Subject:       Munjoy Heights  
                  Final Level III Site Plan Application  
                  Comment Response Letter

On behalf of Redfern Properties, LLC we are pleased to respond to Woodard & Curran's November 20<sup>th</sup>, 2013 Memorandum.

**Woodard & Curran – Peer Review Memo**

| DRAWING NO. C-30 | |

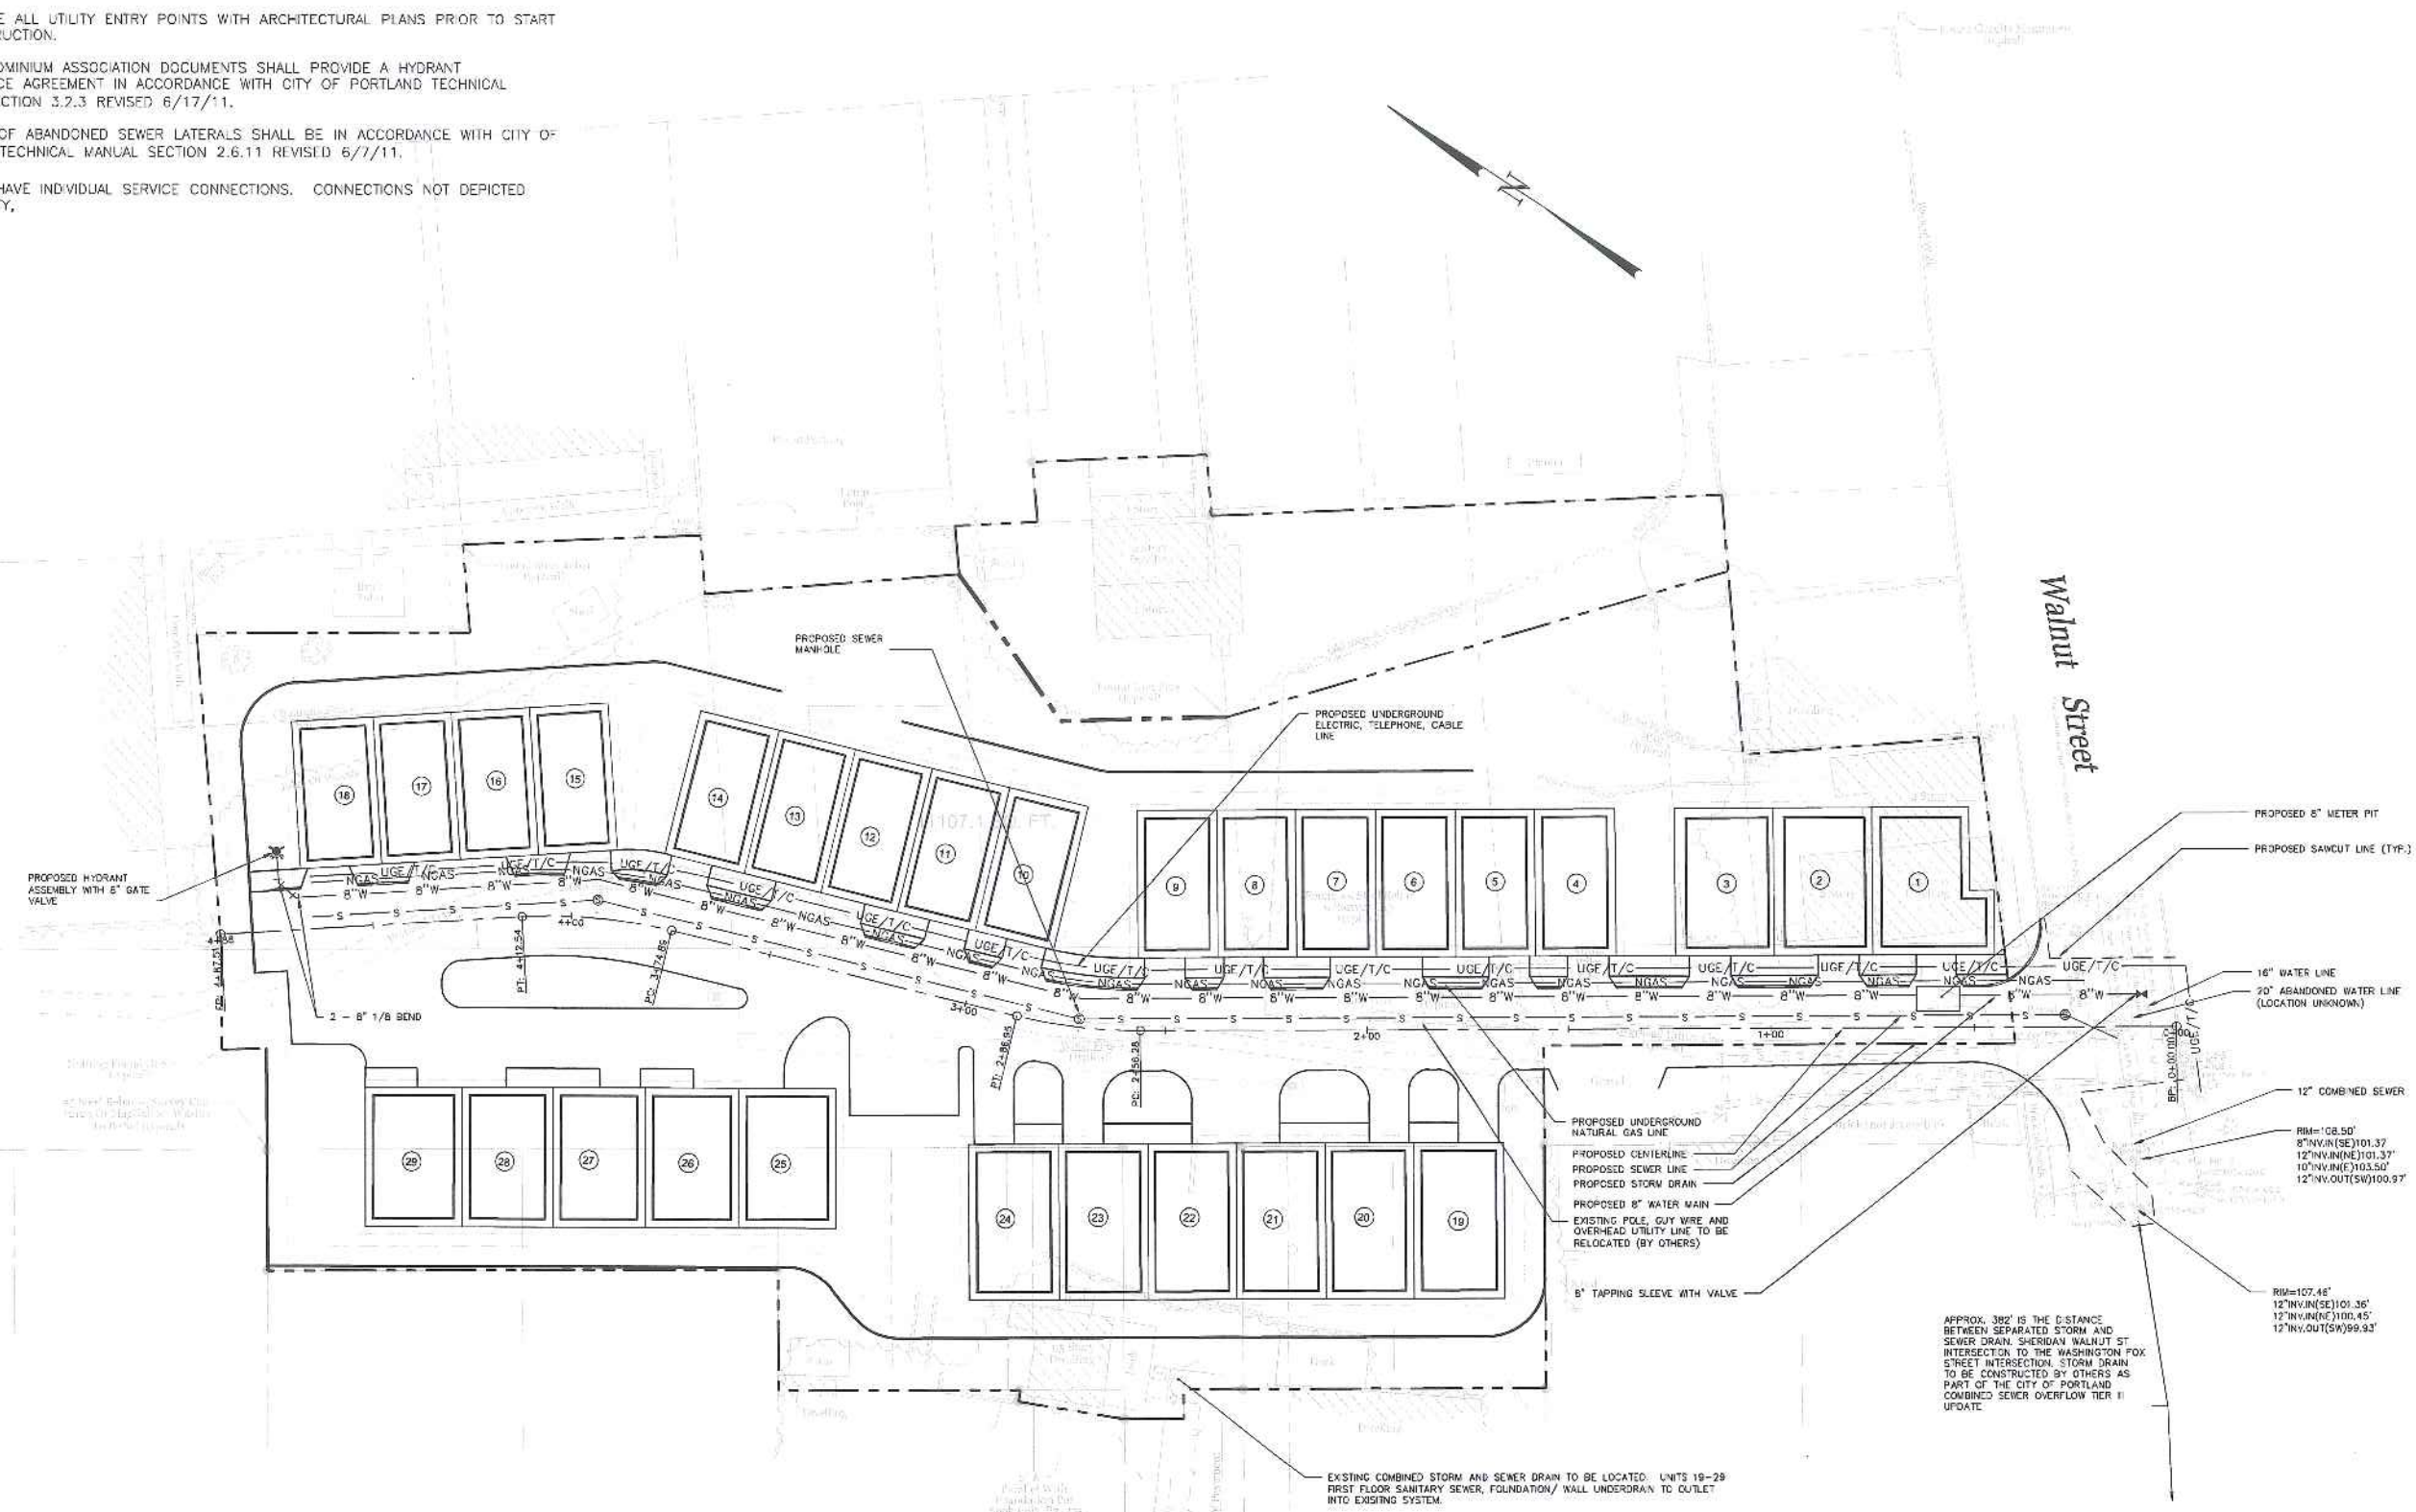
17) *Sheet C-30 indicates a proposed location for potential rain gardens. Future submissions should clarify the design of these rain gardens.*

18) *Sheet C-30, additional detail should be added to the grading and drainage plan to ensure that runoff from the driveway does not enter onto the Rando Parcel (south/west of the entrance driveway).*

20) *Sheet C-30, it is unclear how building roofs are connected to the stormwater collection system.*

**Response** – *Drawing C-30 and C-42 clarify the design of the rain gardens.*

**Response** – This was not addressed on Drawing C-30. A revised drawing will include sloped granite curb to redirect the stormwater towards the proposed rain garden and USSF.

**Response** – Runoff from the roof of building units 1-18 will outlet to the rear of the units onto the ground surface before entering into one of seven field inlets. Units 19-24 will outlet subsurface to the front before entering the drainage system. Units 25 – 29 will outlet subsurface to the front before connecting directly into the side of the StormTech chamber. Runoff from the roof of building units 1-29 will be tributary to the USSF.

DRAWING NO. **C-31**

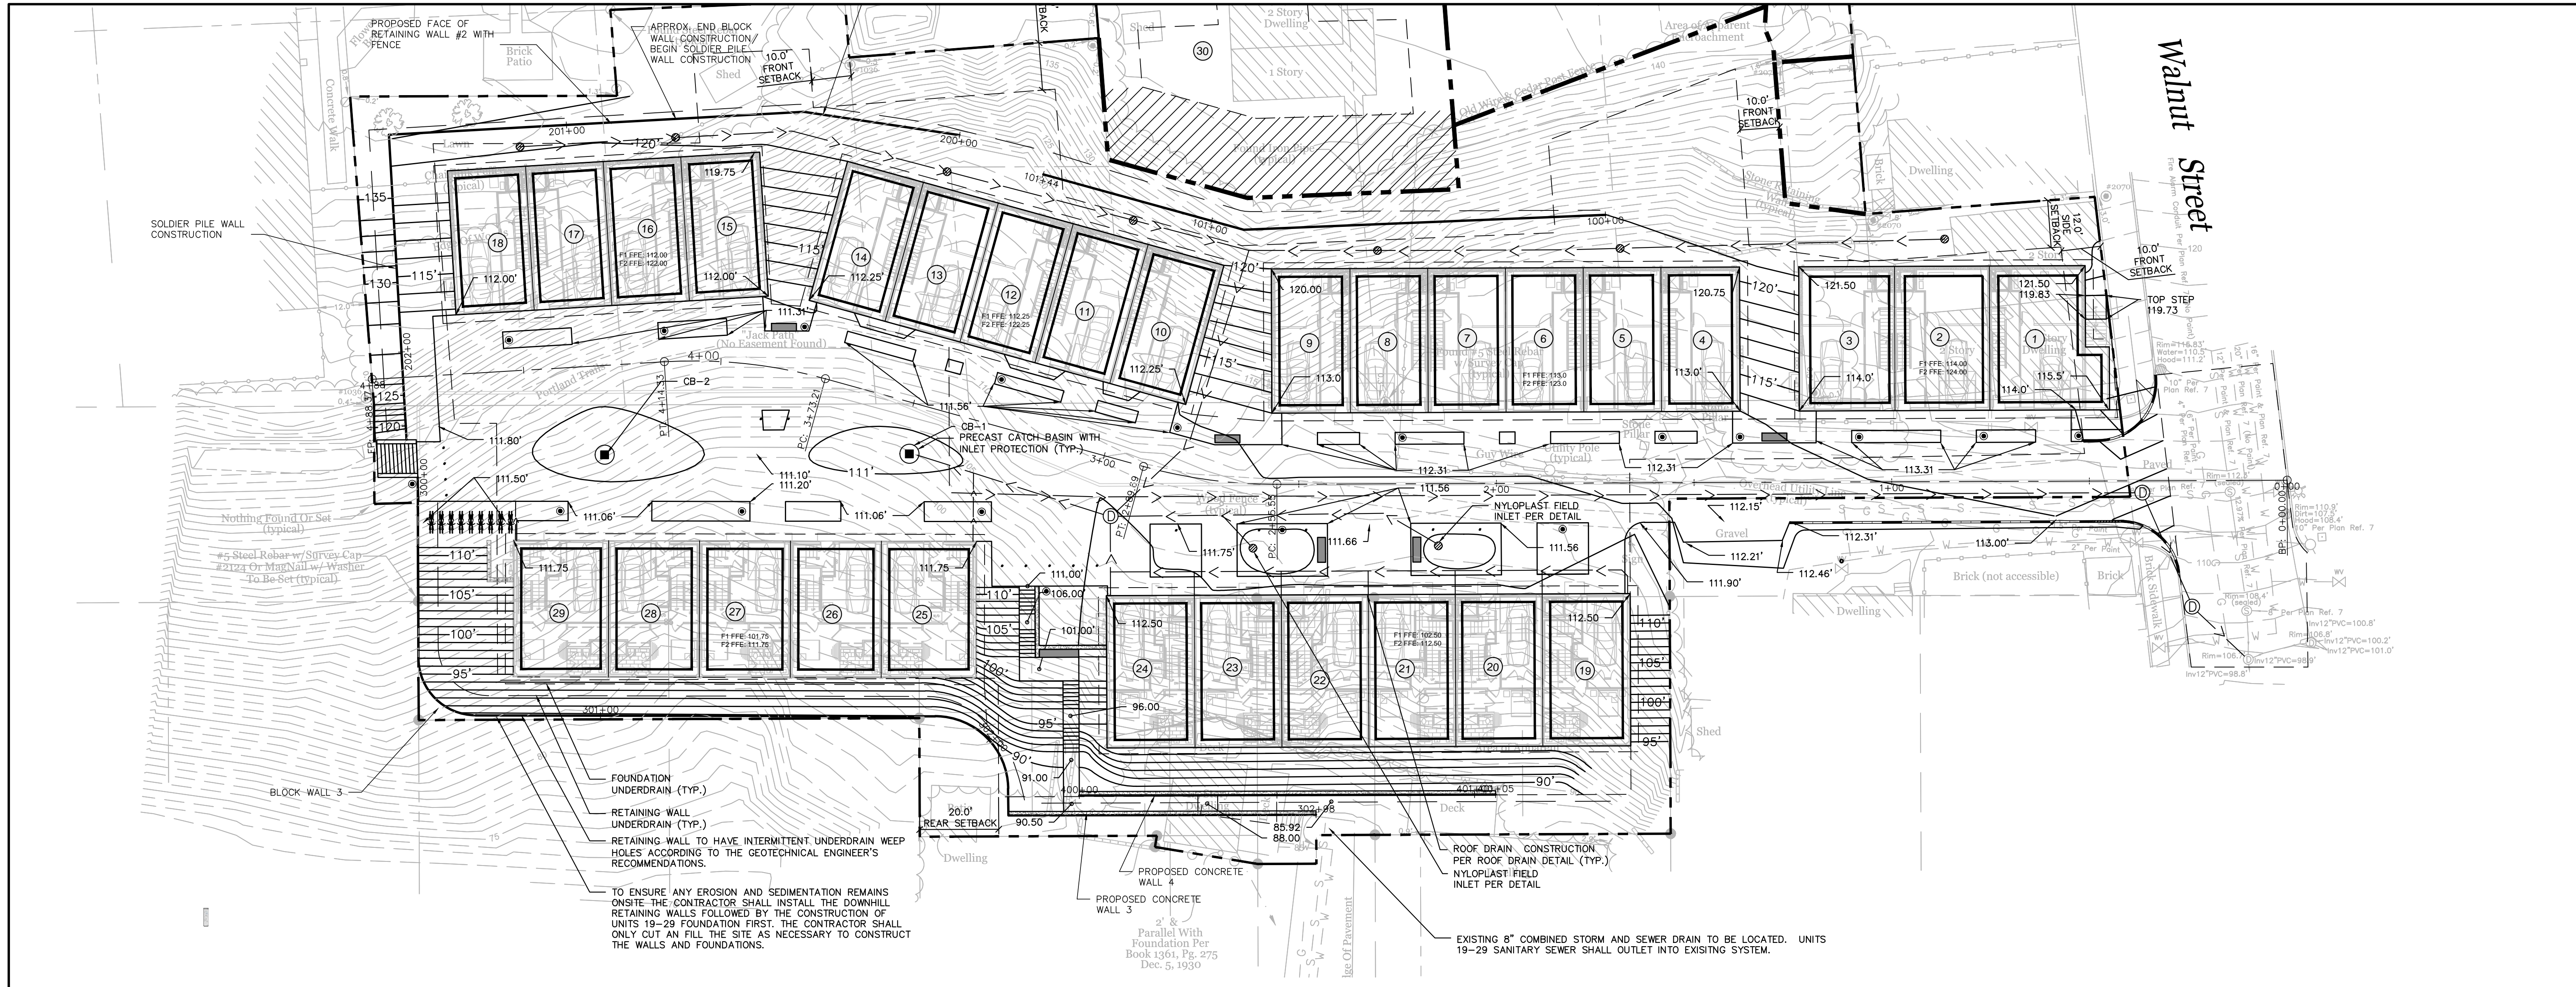
22) *Sheet C-31, the centerline profile indicates that Existing SMH1 and Existing DMH1 in Walnut street have 2’ deep sumps. This would not be a standard condition for City manholes. The applicant should review and revise the plan accordingly.*

**Response** – The two ft. sump was eliminated from the centerline profile for existing SMH1 and DMH1.
